Explanation of Minor Amendments to Plans

The West Midlands Rail Freight Interchange Order 201X

21 May 2019

THE WEST MIDLANDS RAIL FREIGHT INTERCHANGE ORDER 201X
DOCUMENT 12.1 – EXPLANATION OF MINOR AMENDMENTS TO PLANS

B3 - Proposed Road Bridge, Over Existing SI Group Access Road (Section S3)
(Scale 1:50)

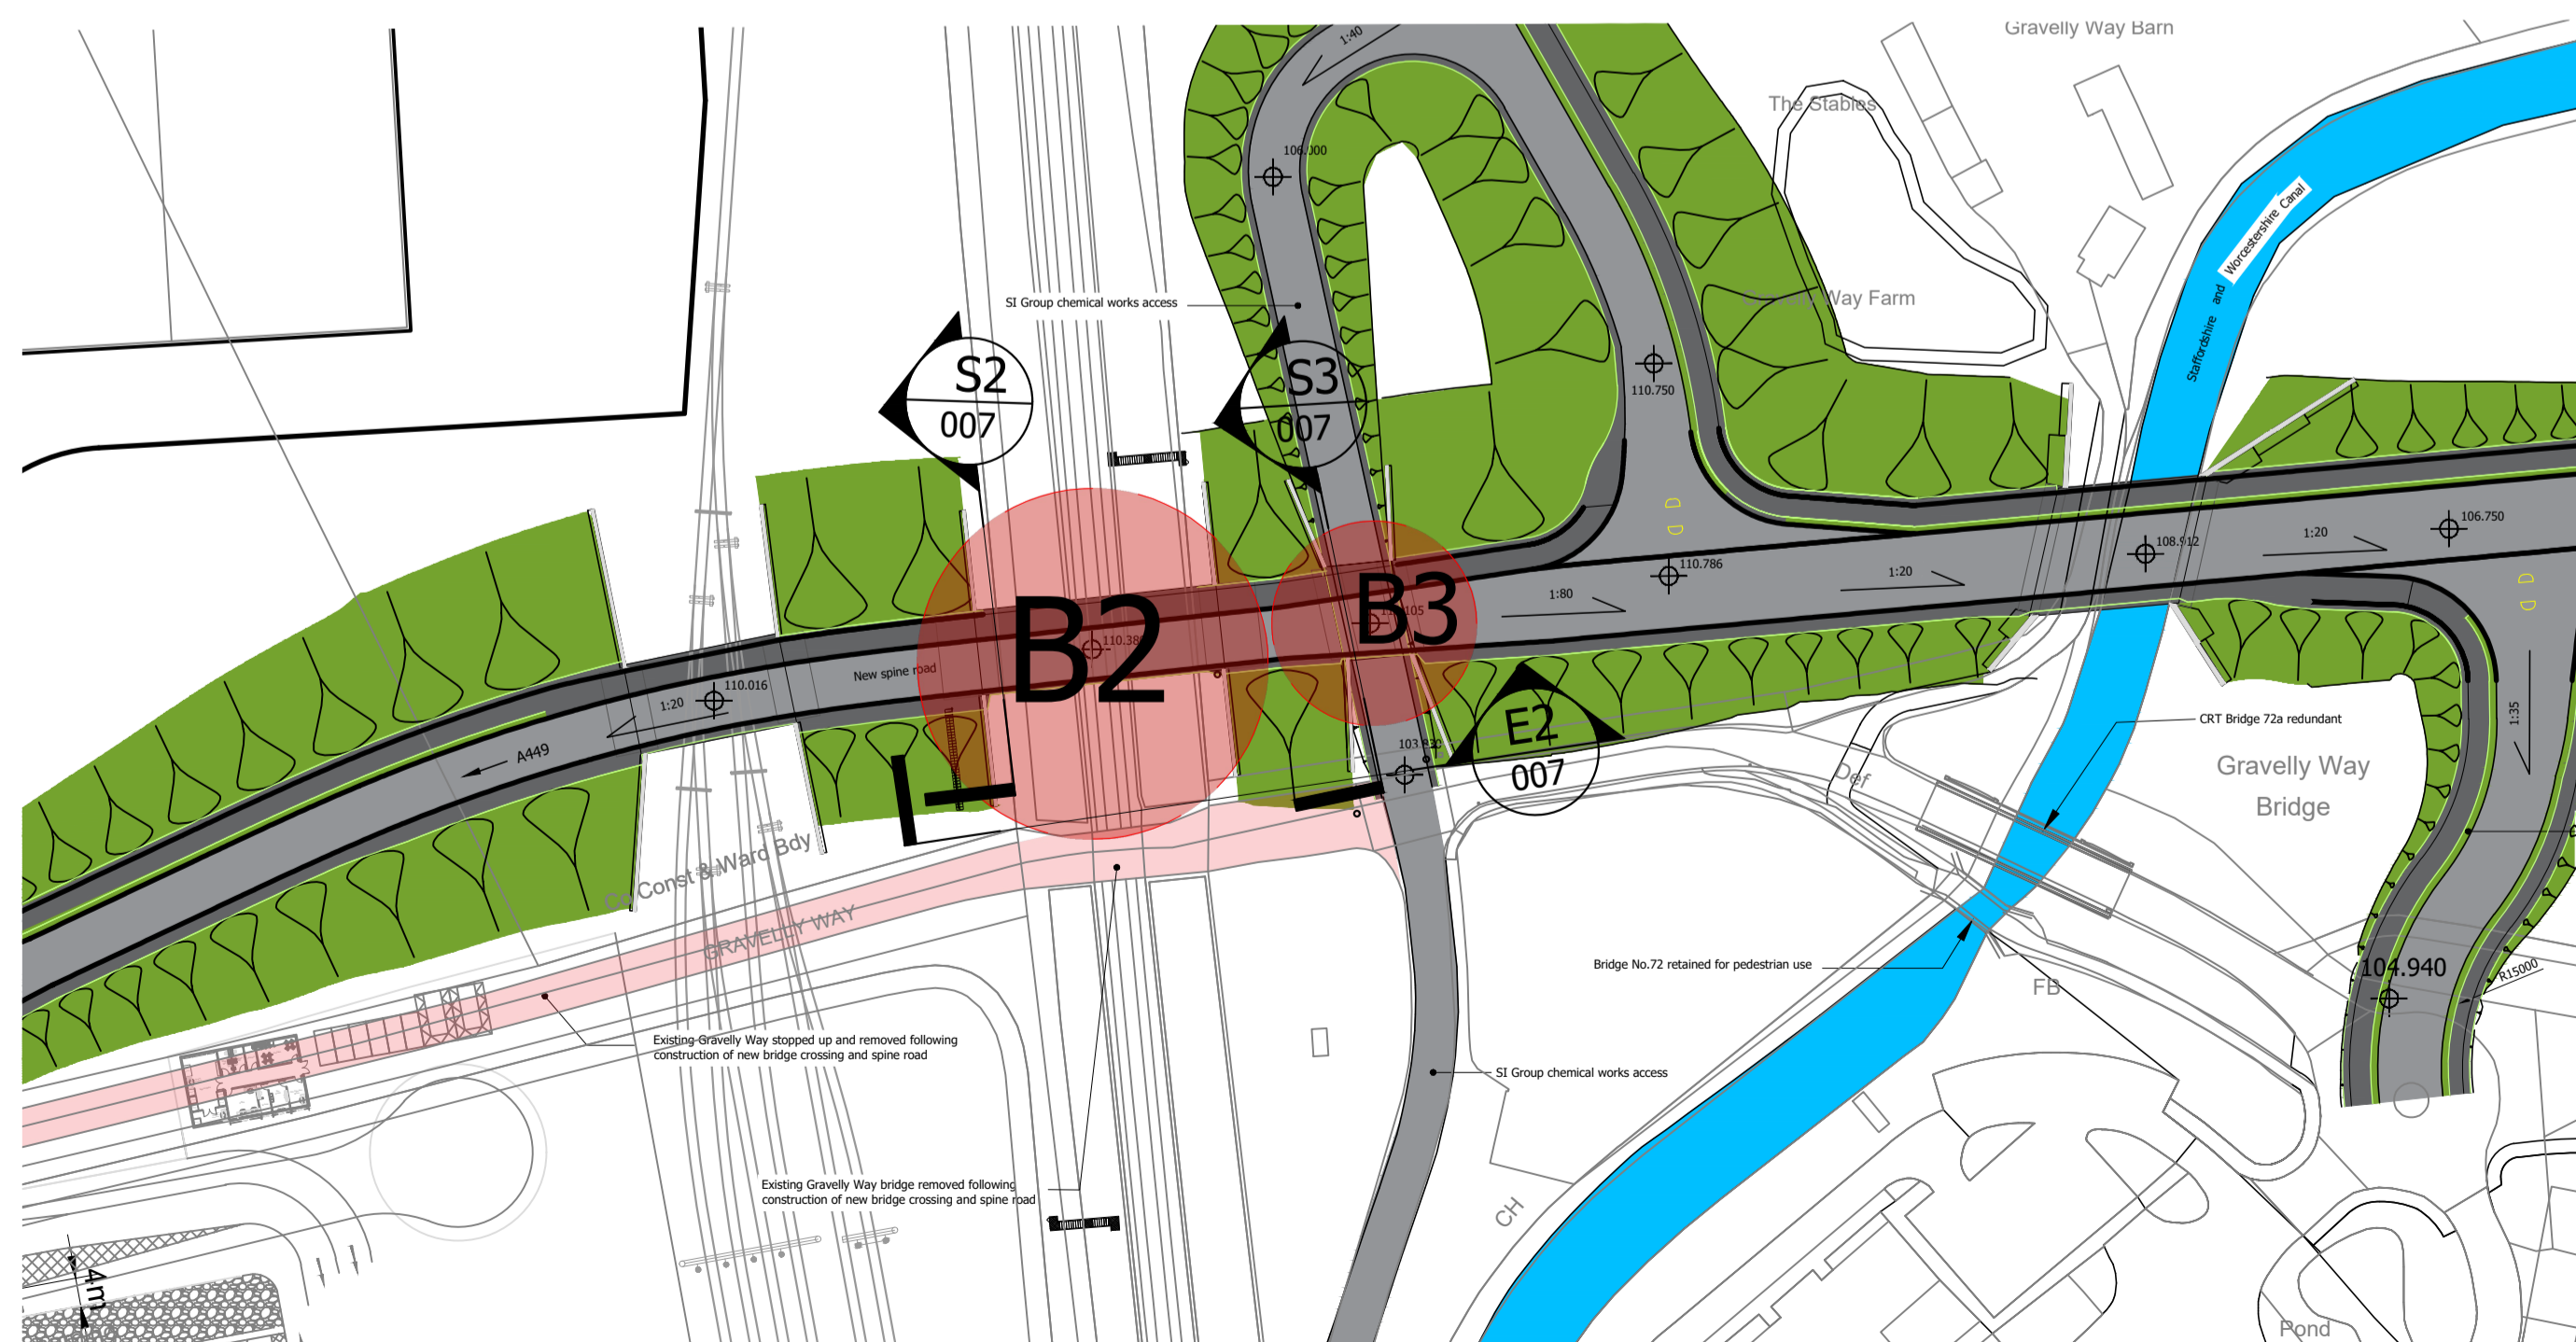
Doc No.	Doc Name	New Plan Rev Number	Changes and Reasons for Changes
Bridge Plans			
2.18A	Proposed Road Bridges Plan and Long Section	P8	To allow better cross reference to levels for limits of deviation in article 4 of the dDCO.
2.18B	Proposed Road Bridge B1 Section and Elevation	P11	As above.
2.18C	Proposed Road Bridge B2 and B3 Section and Elevation	P11	As above.
2.18D	Proposed Road Bridge B4 Section and Elevation	P14	As above.
